**Building 457 Village Centre South (Phase 2)
Heyford Park Camp Road Upper Heyford Bicester
OX25 5HD**

19/02337/F

Proposal: Demolition of Building 457 southern facade and gable end walls.
Temporary use and associated works to create public open space.

VILLAGE CENTRE SOUTH (PHASE 2), HEYFORD PARK - EXISTING SITE PLAN

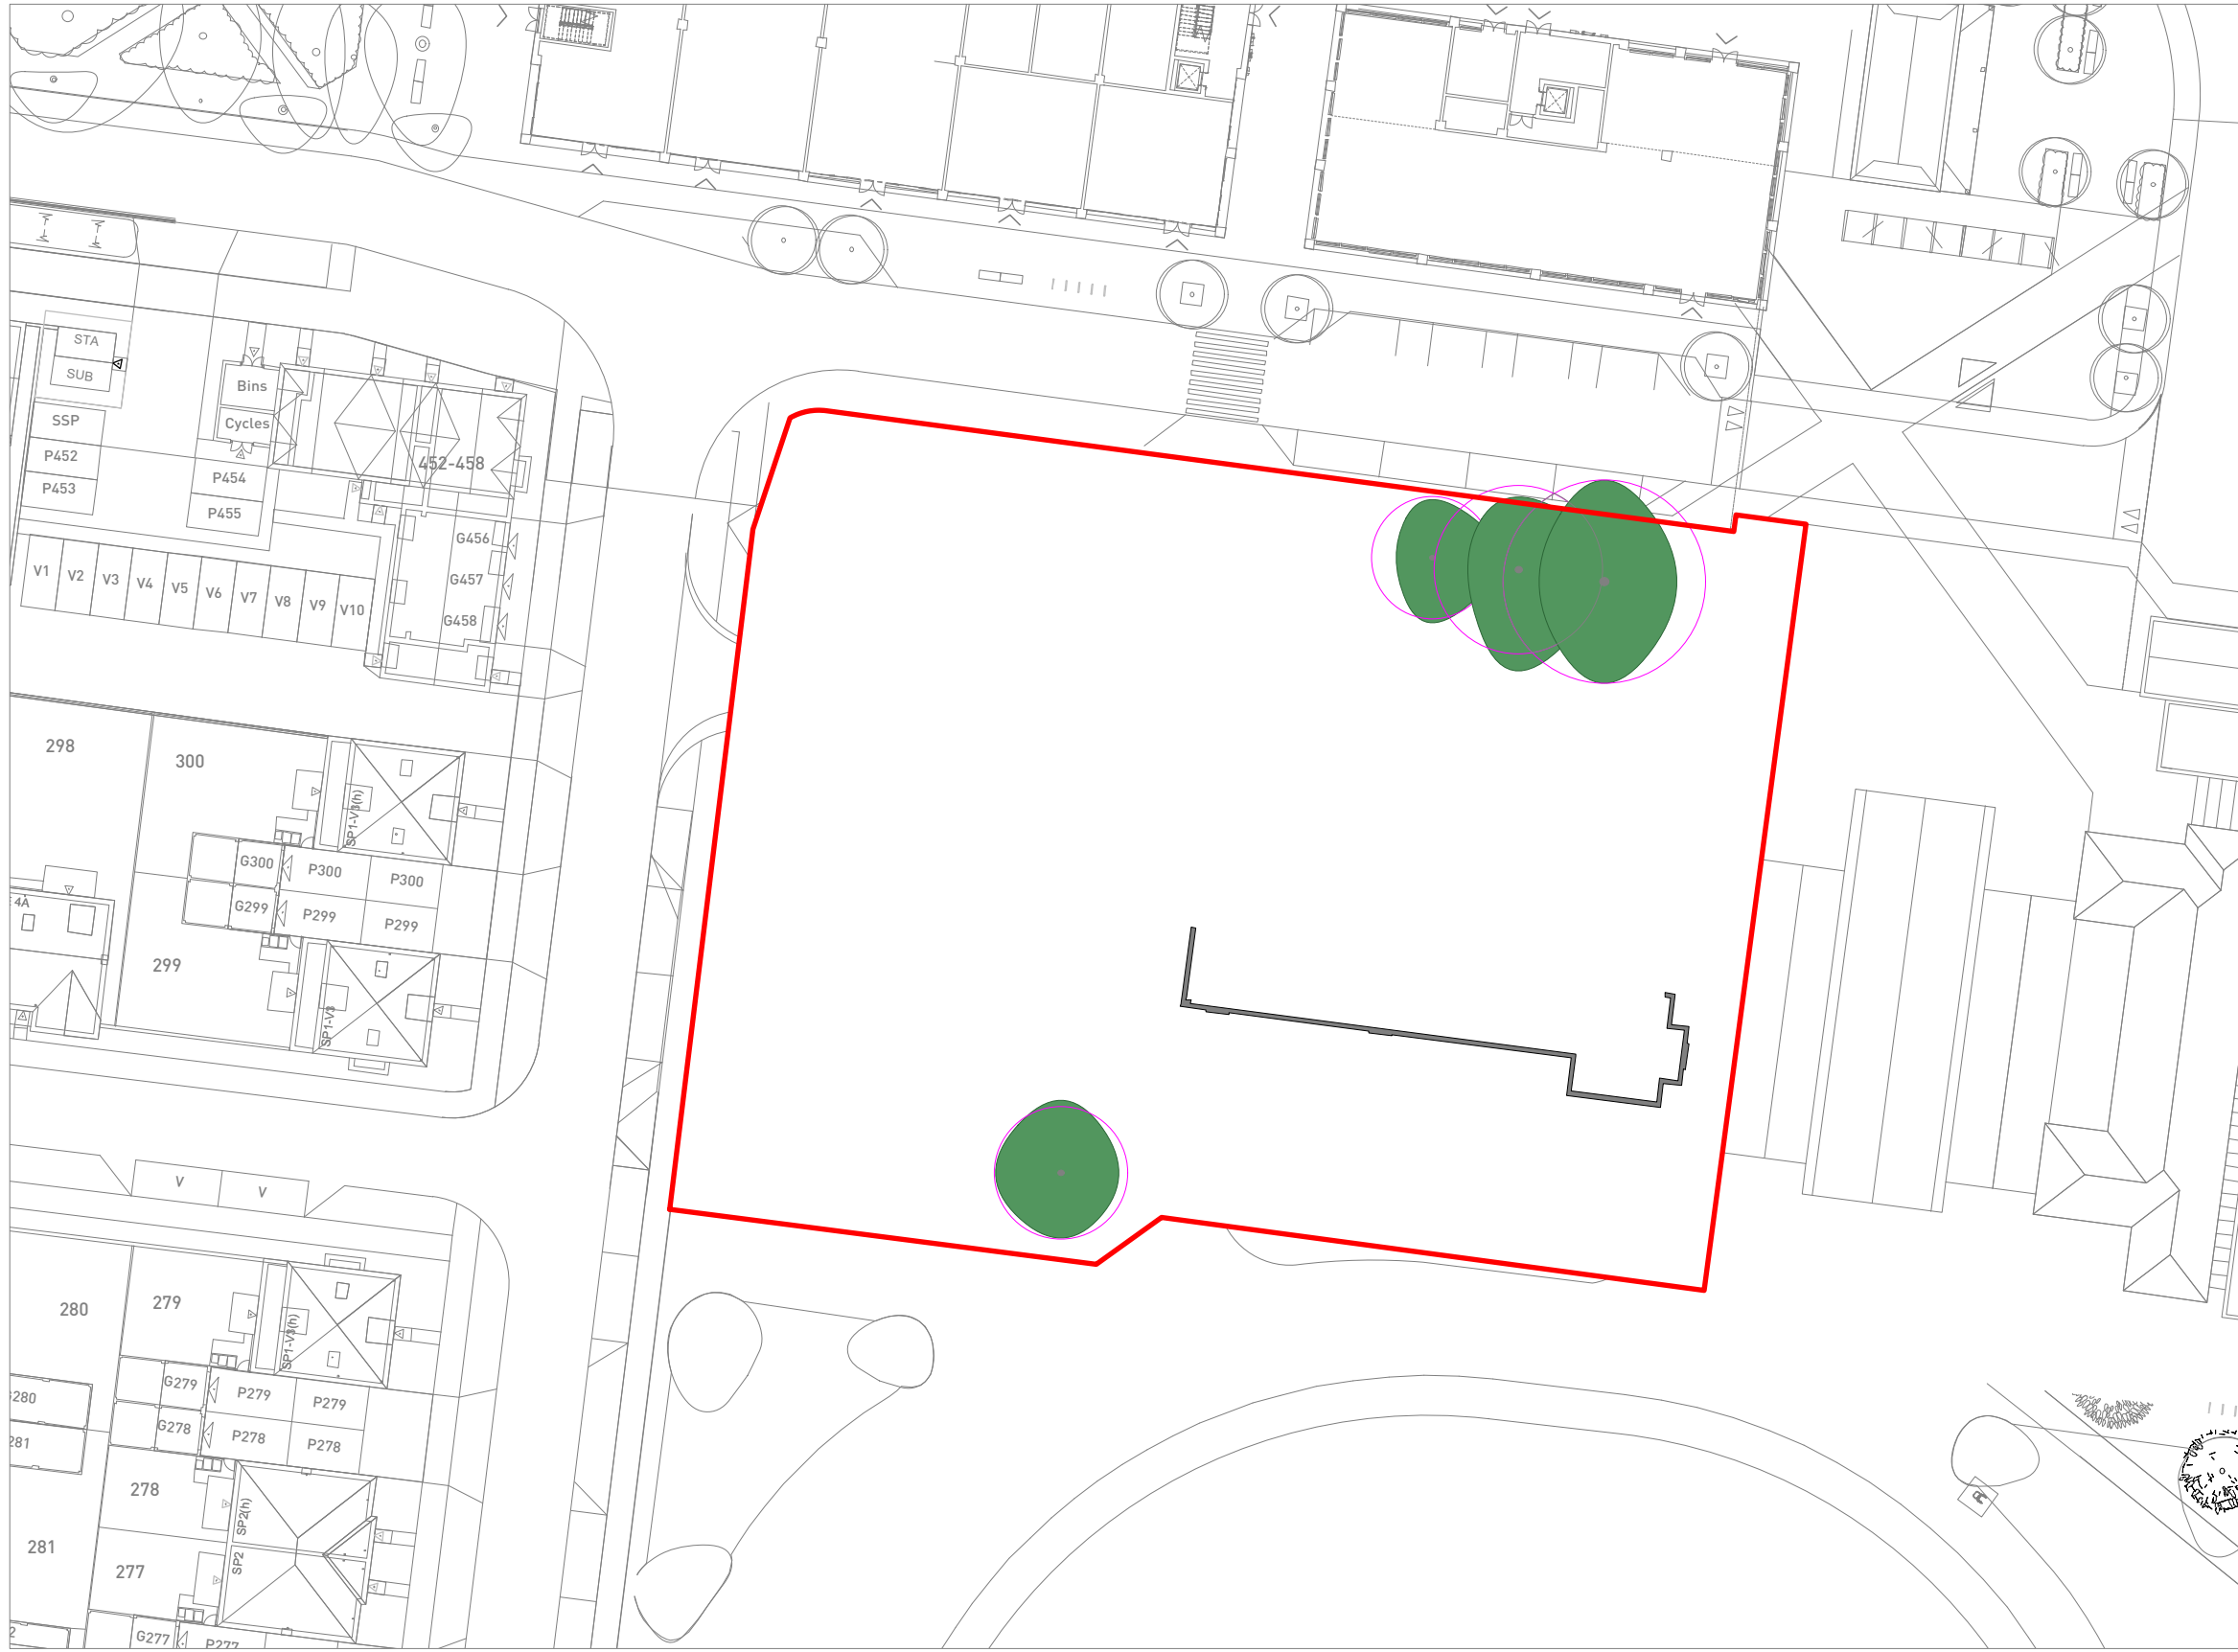
6.7. CDC LANDSCAPE SERVICES: **No objections**, but comments that the landscaping proposals appear rather bare and are lacking in detail (e.g. planting around seating area; measures to restrict vehicular access such as bollards or knee rails). Tree protection measures should be incorporated.

6.8. CDC BUILDING CONTROL: **Comments** *"Without the scaffolding in place my opinion would be that the unrestrained gable ends, walls stacks etc would not be*

structurally stable. My advice is that if the facades are to be retained a structural engineers input should be sought to establish and confirm stability in that form”.
